PLAN-010898

Proposal: Single storey side extension.

Site: The Paddock, Lidsey Road, Aldingbourne, PO20 3SU.

AL/78/15/HH

01 - Site Plan as Existing.

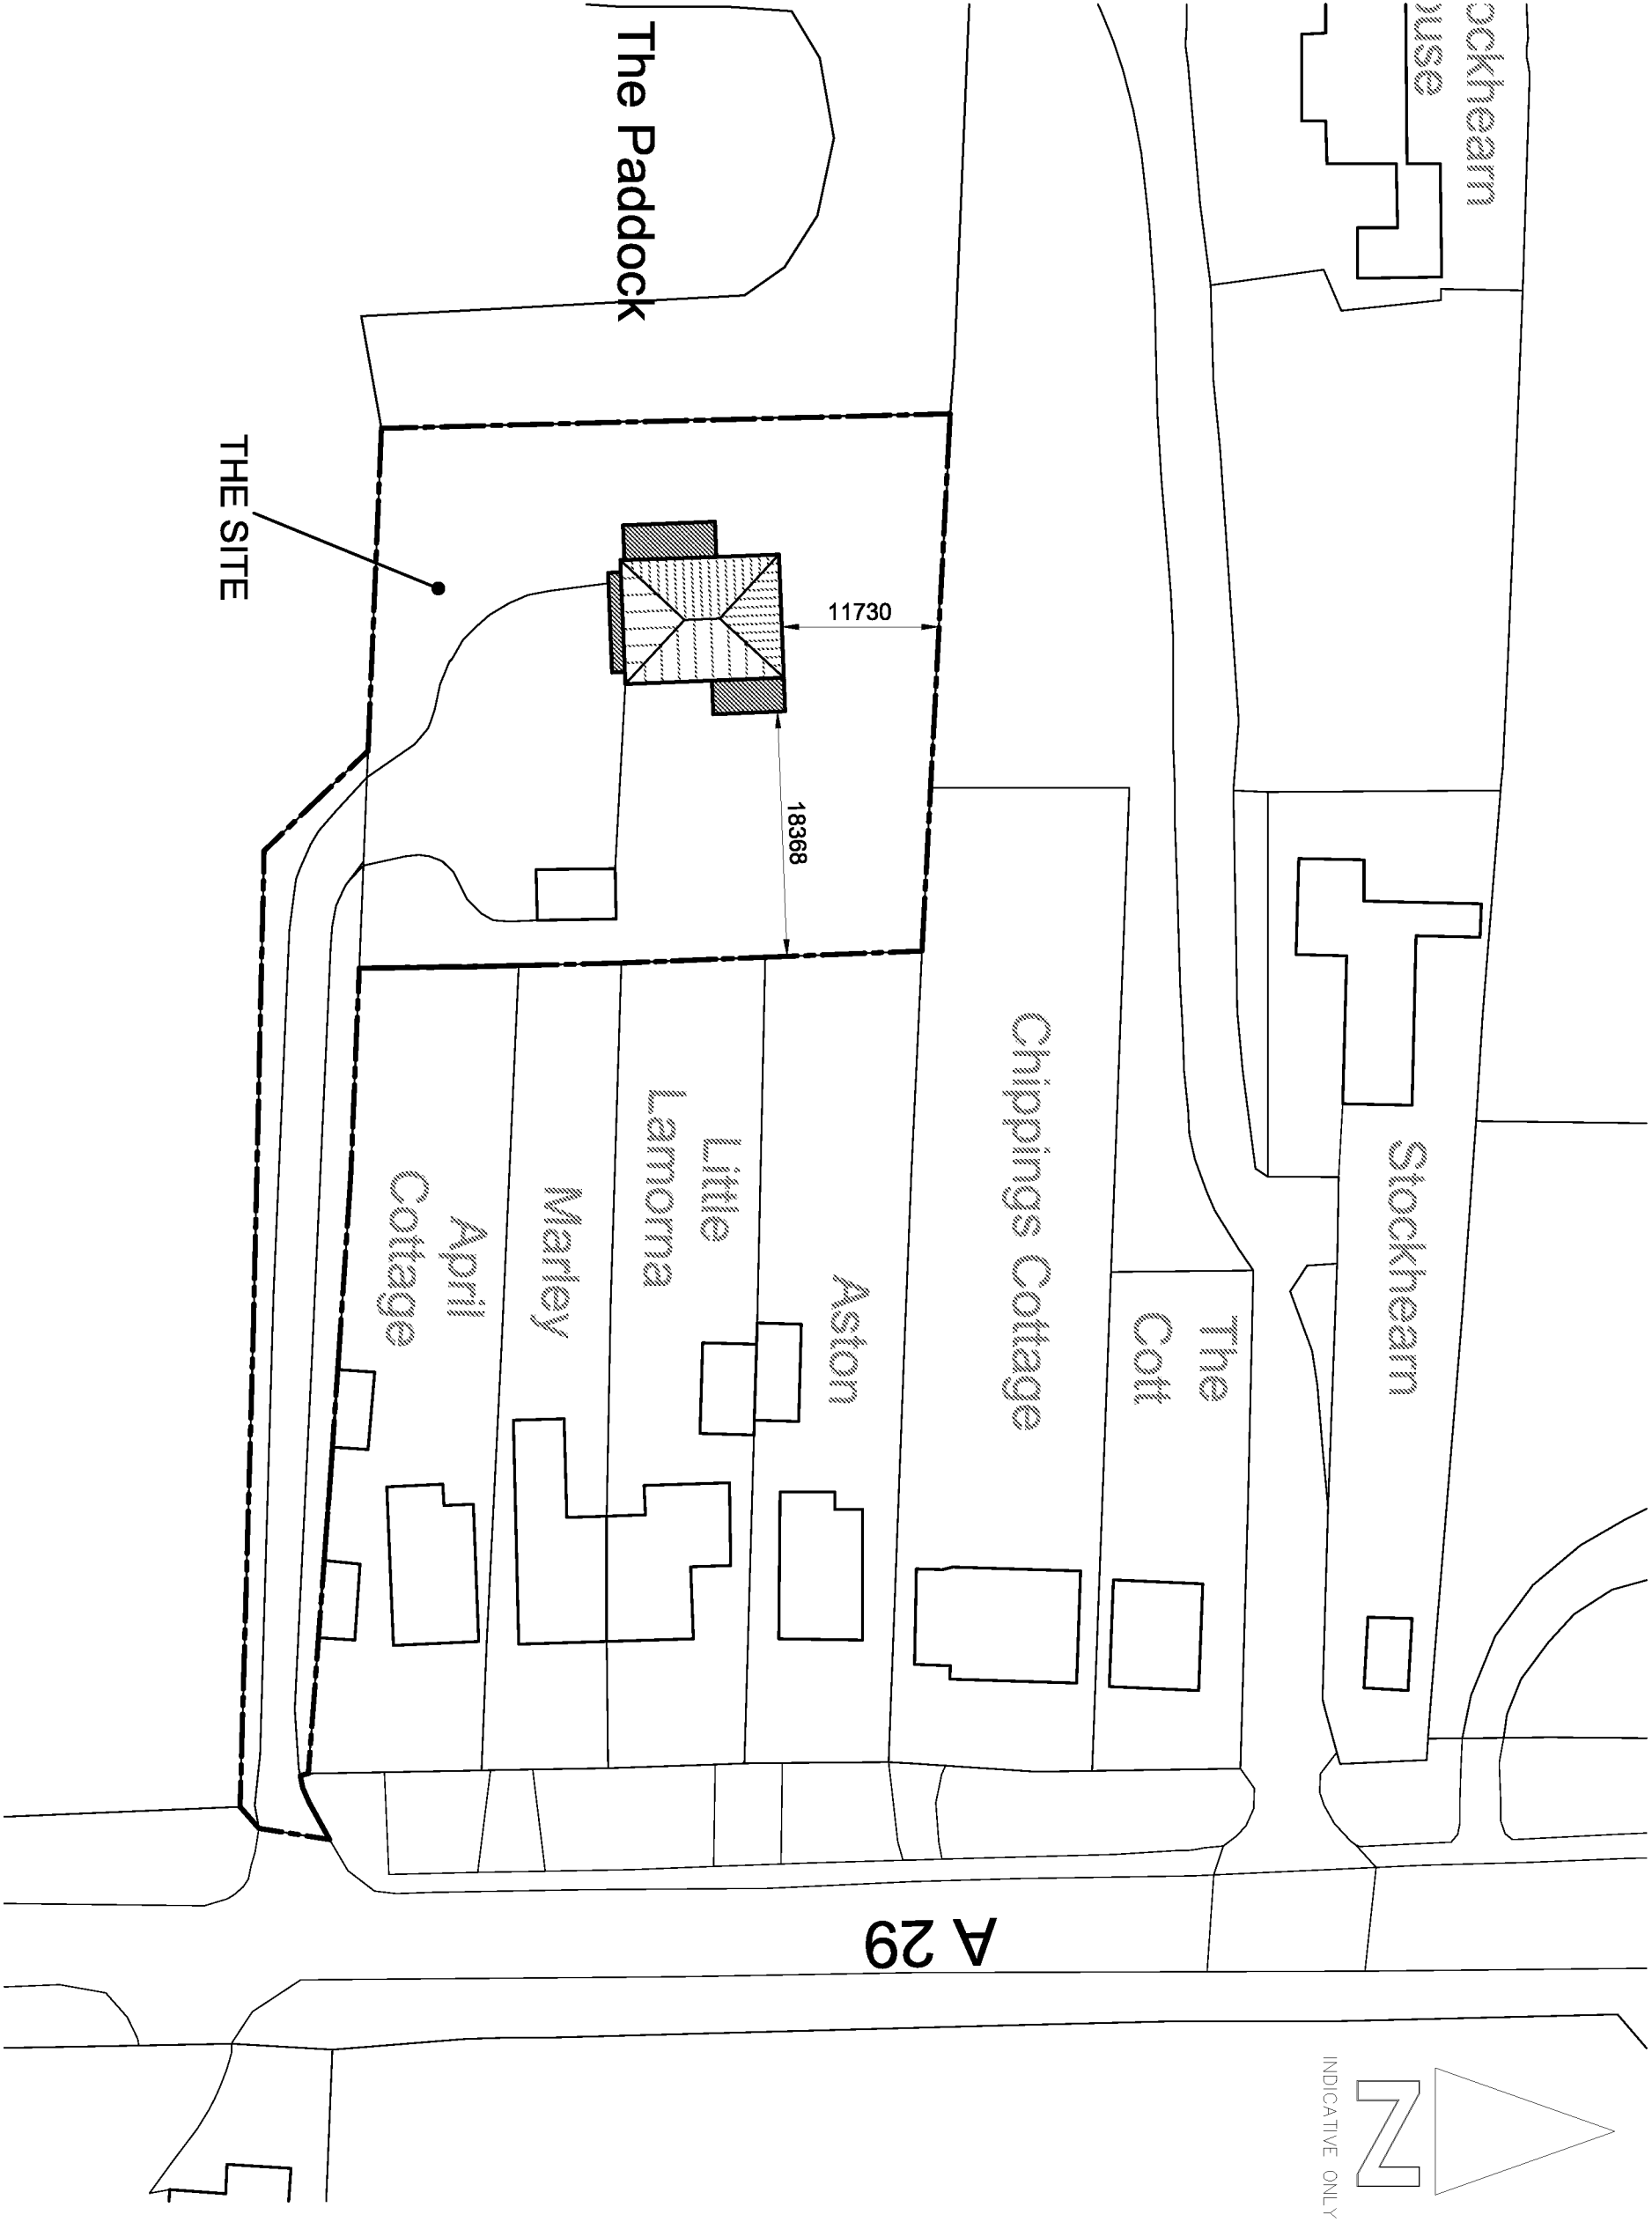
Our initial investigations indicate that there are no public surface water sewers in the immediate vicinity to serve this development. Alternative means of draining surface water from this development are required. This should not involve disposal to a public foul sewer.

Please find attached a plan of the sewer records showing the approximate position of foul sewer within the access of the site. The exact position of the foul sewers must be determined on site by the applicant before the layout of the proposed development is finalised.

- No development or new tree planting should be located within 3 metres either side of the centreline of the foul sewer.
- No new soakaways should be located within 5 metres of a public sewer.
- All existing infrastructure should be protected during the course of construction works.
